**Project MetroLink - 13-14 Earlsfort
Terrace, Rear Of 15-18 Earlsfort Terrace
And 17-19 Hatch Street Lower, Dublin 2
(And Also Known As 10 Earlsfort Terrace) -
PUNCH Civil/Structural Engineering Report
- Module 1**

222202-PUNCH-XX-XX-RP-S-0001

This report has been prepared as part of a submission by Earldev Properties Unlimited Company (Earldev) for the An Bord Pleanála Oral hearing relating to the Dublin MetroLink project - Ref ABP-314724-22 Submission Number 079. The report covers Structural Civil Engineering matters specific to the site. It is noted from the outset that Earldev are fully supportive of the Dublin MetroLink Project. There are however a number of areas of concern of Earldev and their Technical Team, which we request are fully addressed to ensure the building is not damaged beyond its design limits during any tunnel works.

Drawing file: Day 11 - 6th March 2024 / No.01 - TII - Revised Drawings Updated Tunnel Alignment St. Stephen's Green-Charlemont RO Application Alignment and Deeper Vertical Al

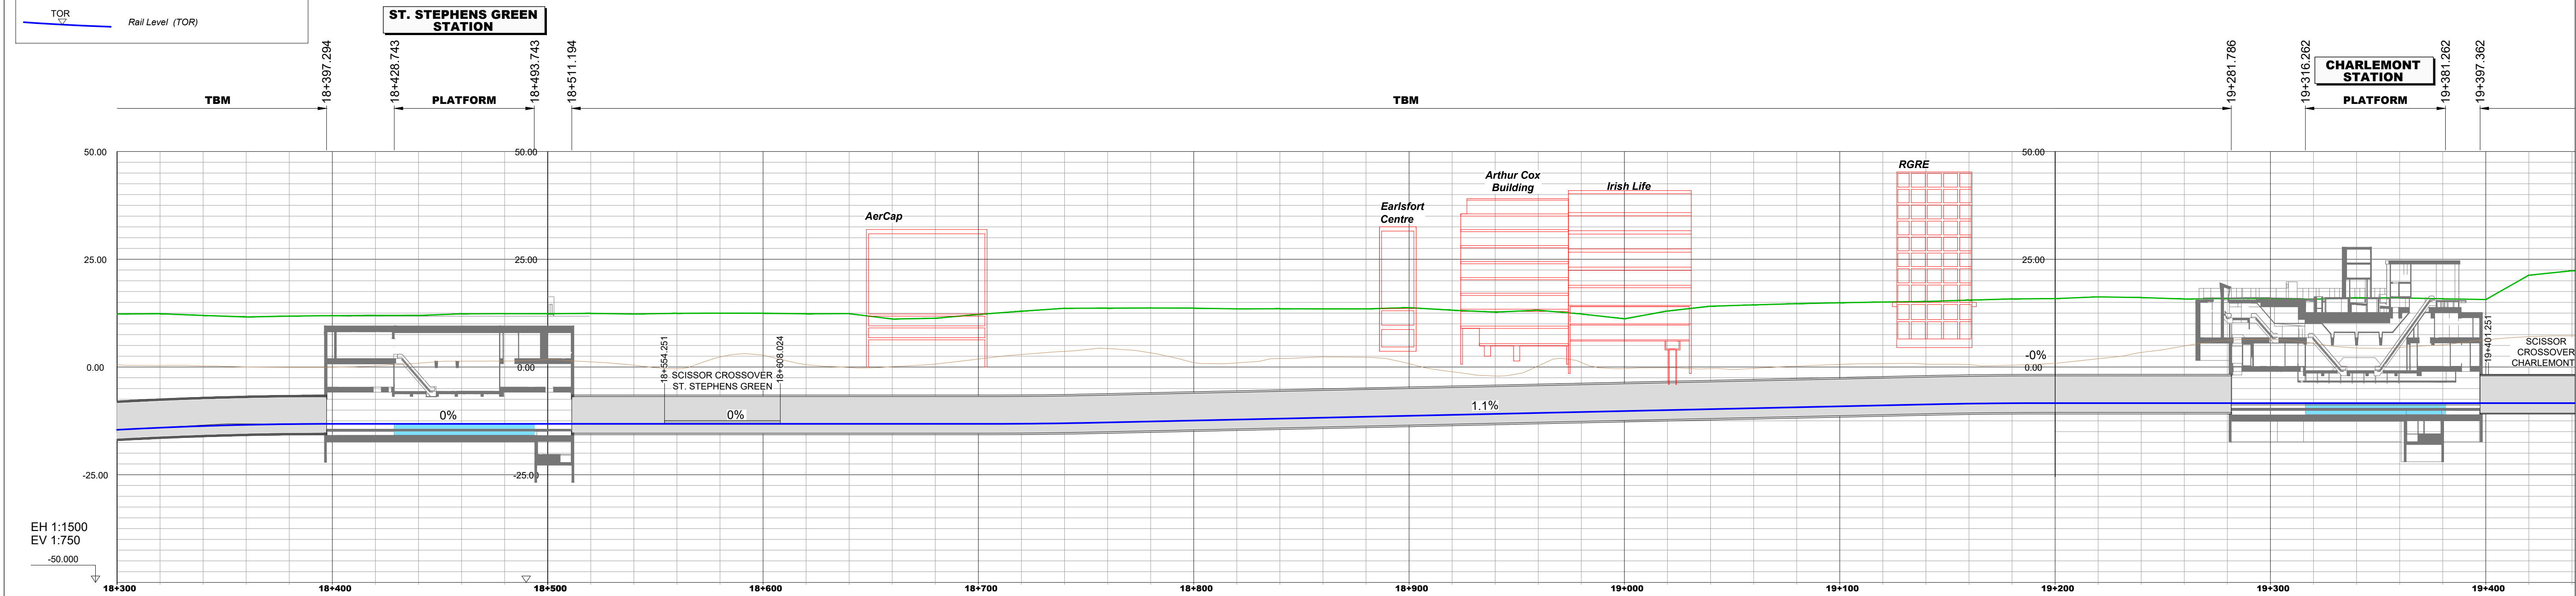
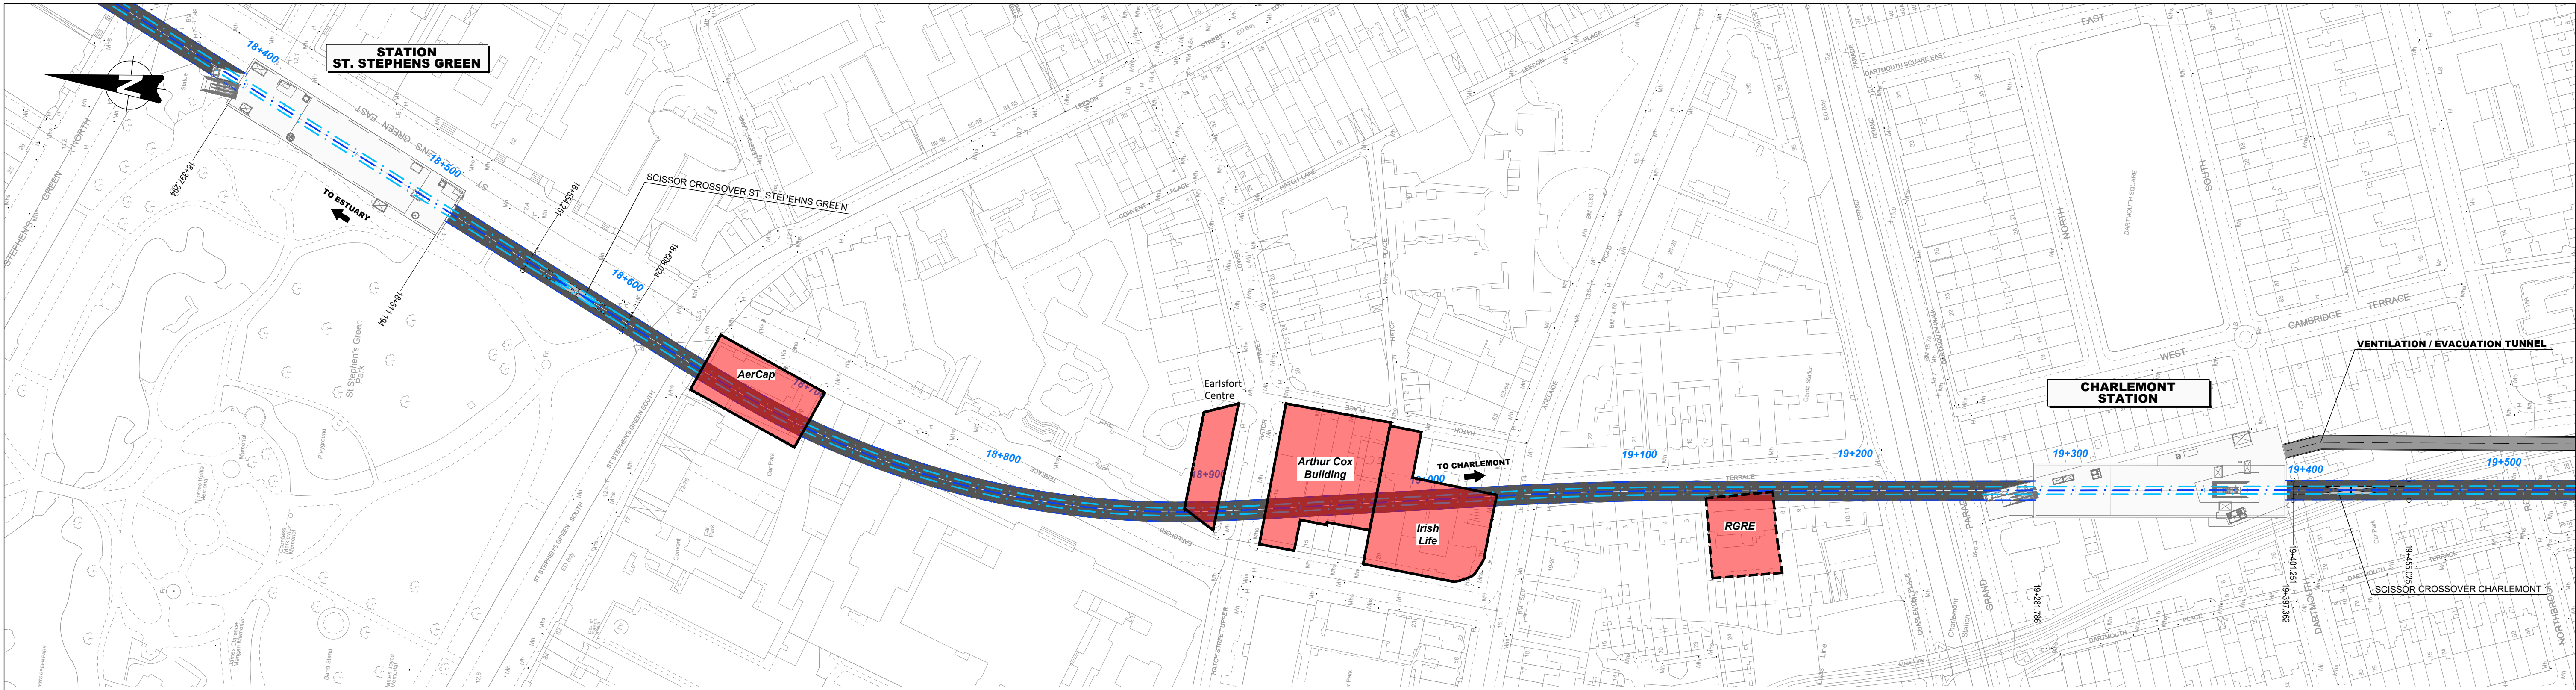
It was originally proposed in the EIAR that the upwards vertical deviation was +5m. This would increase the proposed tunnel crown levels to 0.62mod to 1.52mod from north to south. The toe of the piles of the building are at 0.65mod, therefore this upward deviation would result in a clash with the piles. Please refer to sections and 3d images in Appendix D.

On the 19th of February 2024 it was proposed by TII that the upward vertical deviation was to be limited at +1m. As a result of this deviation, this would increase the proposed tunnel crown levels to -3.48mod to -2.48mod from north to south. The toe of the piles of the building are at 0.65mod, therefore this upward deviation would give a clearance of 3.13m from the crown of the tunnel to the piles. Please refer to sections and 3d images in Appendix D.

It was proposed in the EIAR that the downward deviation is -10m. This would decrease the proposed tunnel crown levels to -14.38mod to -13.48mod from north to south. AGL analysis which will be discussed in greater detail by Mr. Conor O'Donnell, reviewed the level of a -5m deviation. The toe of the piles of the building are at 0.65mod, therefore this downward deviation would give a minimum clearance of 9.13m from the piles. Please refer to sections and 3d images in Appendix D.
